PINS Ref: TR010021
LBN Ref: 16/02991/DCO

Application by Transport for London (TfL) for an Order Granting Development Consent for the proposed Silvertown Tunnel ('the Scheme')

Deadline 2:

Statement of the London Borough of Newham

Figure 2-1 Process to determine the need for and mitigation

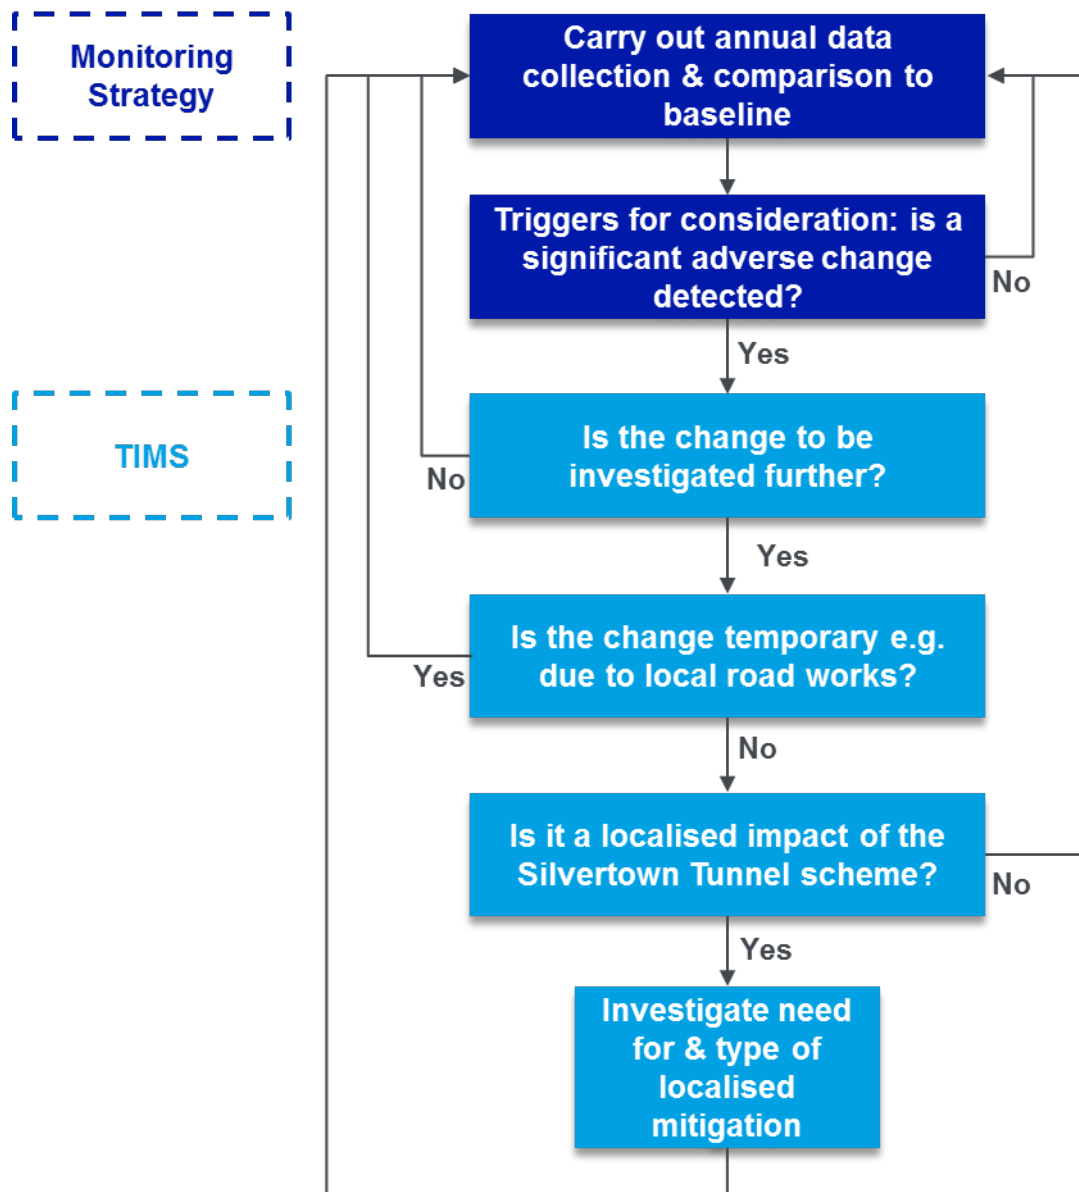
- This mitigation issue is of further concern when examining the suggested frequency of STIG meetings in the TIMS, which are suggested to occur not more than once per year. The prospect of an impact being unaddressed for a period of months because of the timing of meetings where mitigations are discussed is entirely unacceptable, and the frequency of meetings must be dictated by monitoring data – which should be continuous.
